CITY OF ALBUQUERQUE

**RE: Village at Avalon Apartments
601 90th Street NW - Buildings #5
Request for Permanent C.O. – Not Accepted
Building Permit - 2016-00352
Engineer's Certification Dated 12/18/17
Hydrology File: K09D040**

CG-102

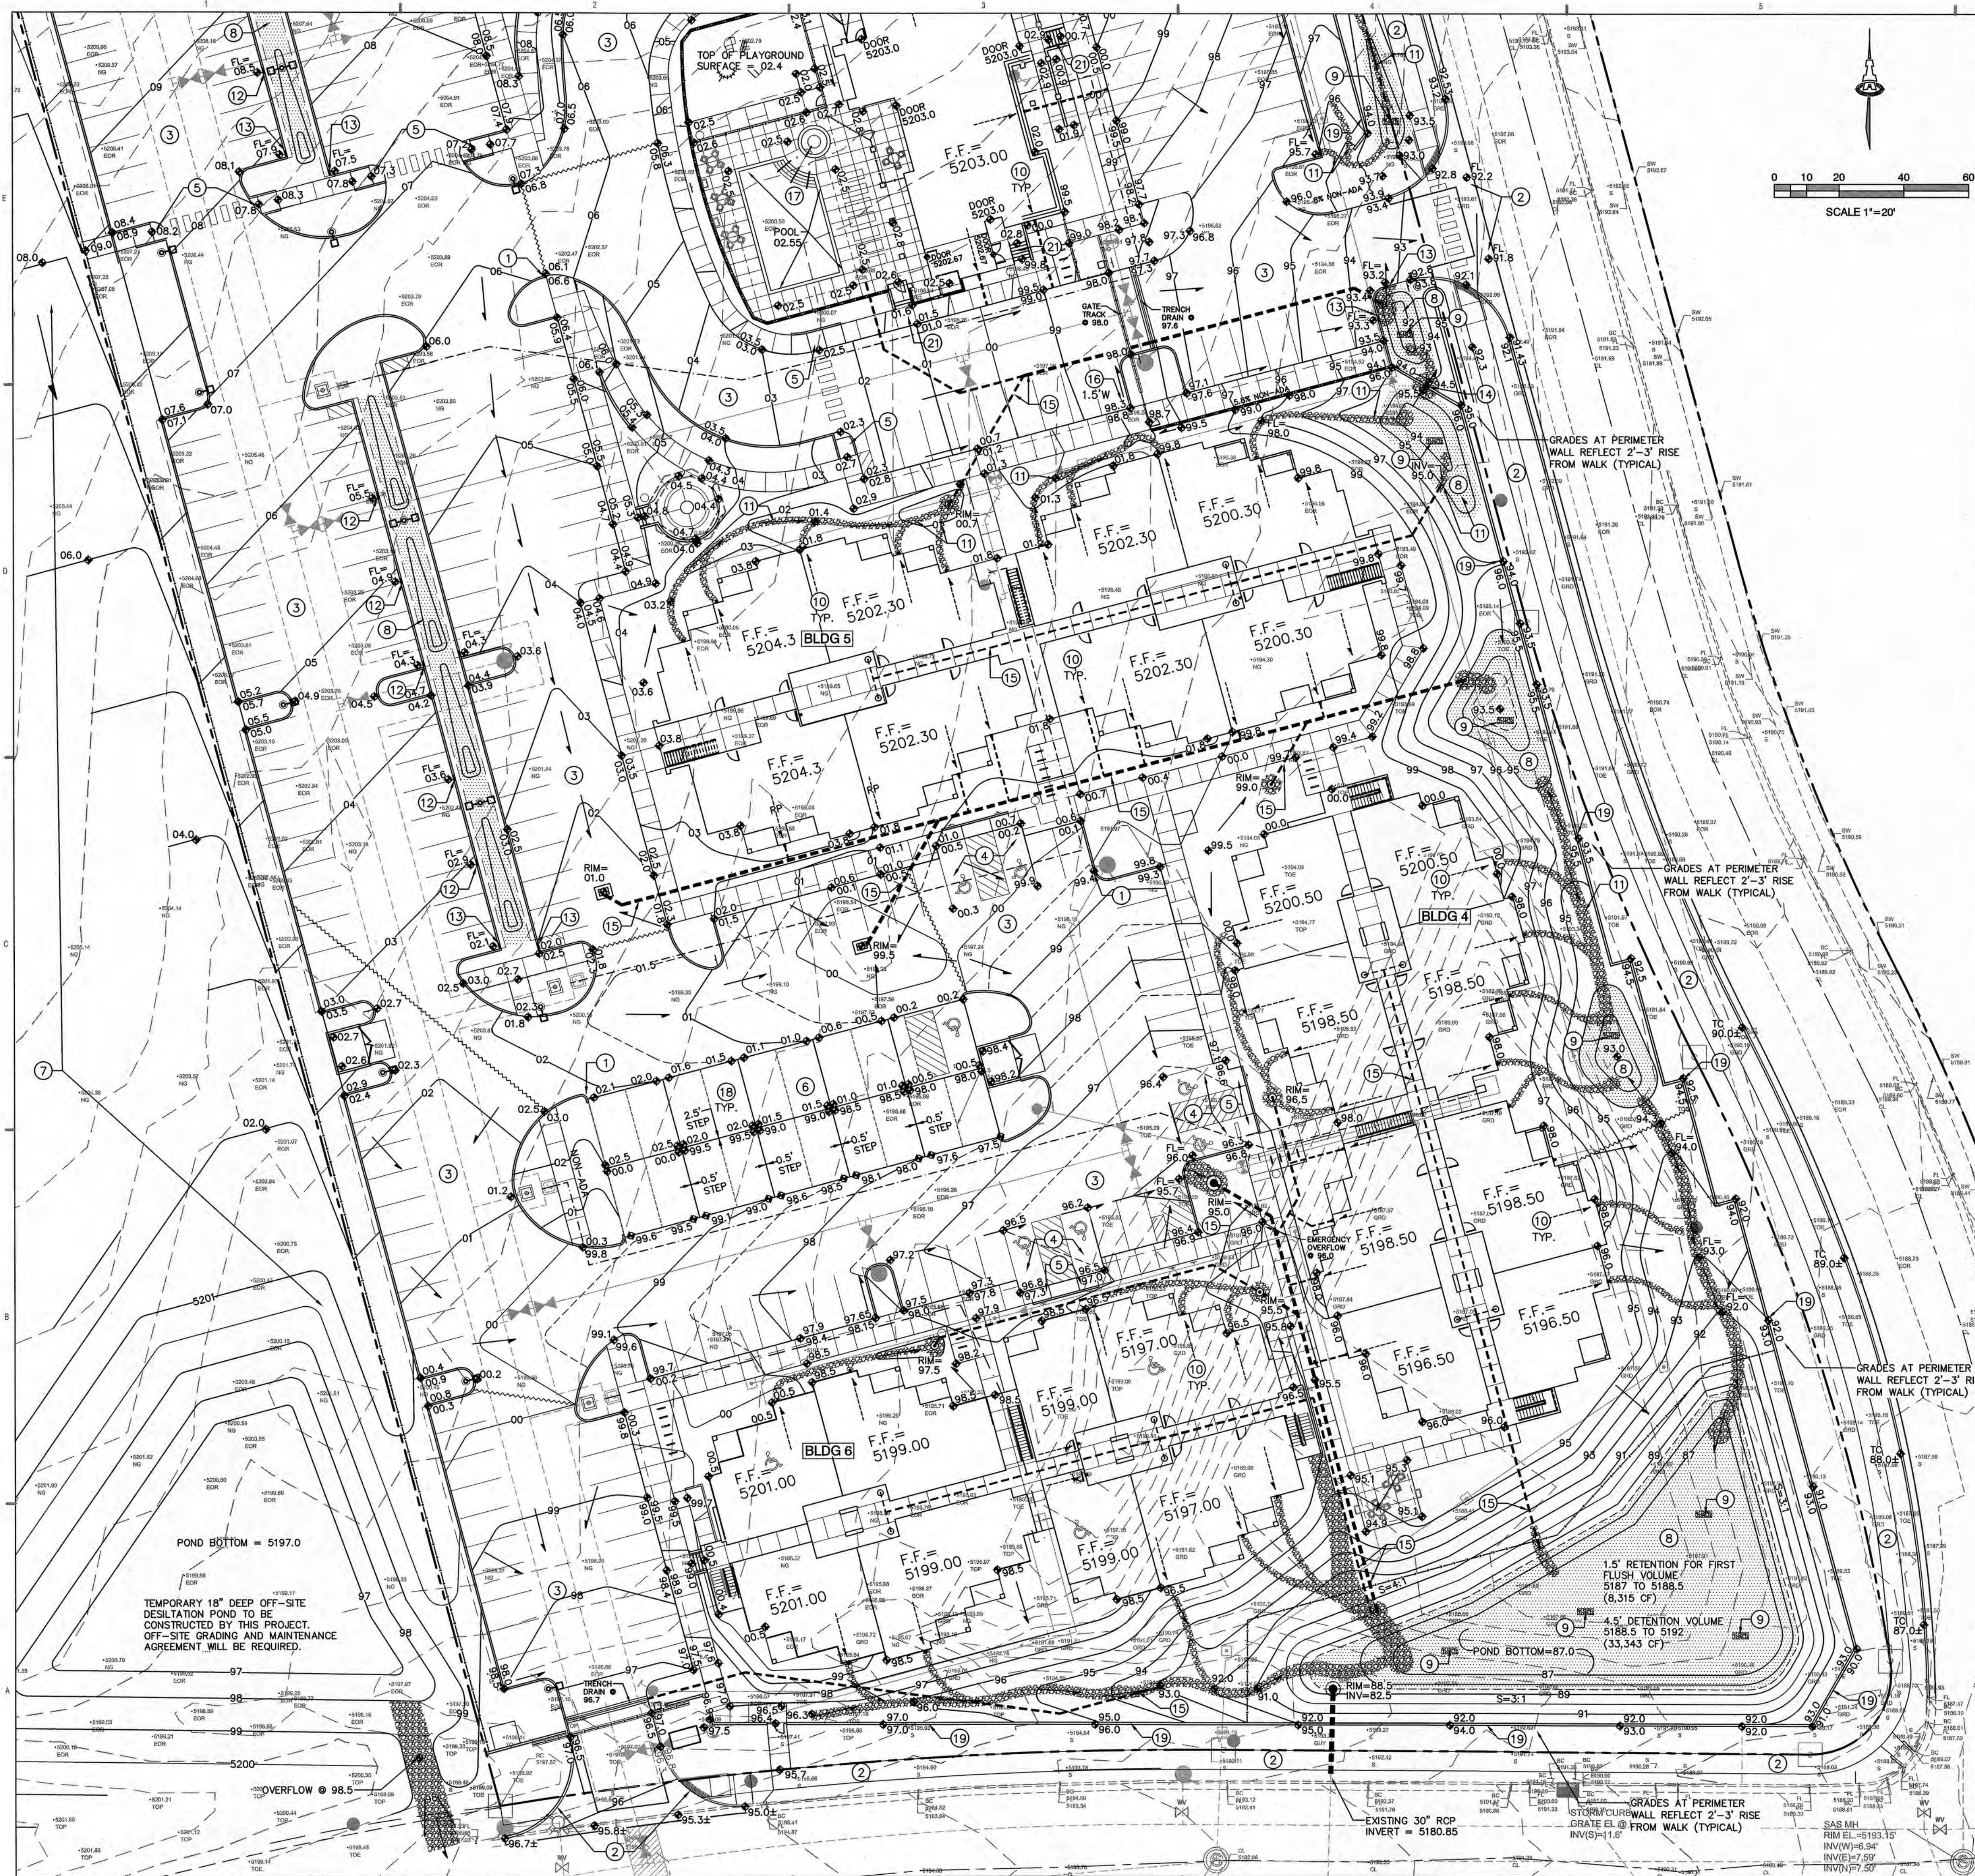
1. According to the Grading Plan Keyed Note #14 and your August 18, 2017 deficiency notation #11, there was to be provided a 2 feet wide x 6 inch high (min) opening through wall at flowline elevation shown to pass flow. This has yet to be done.
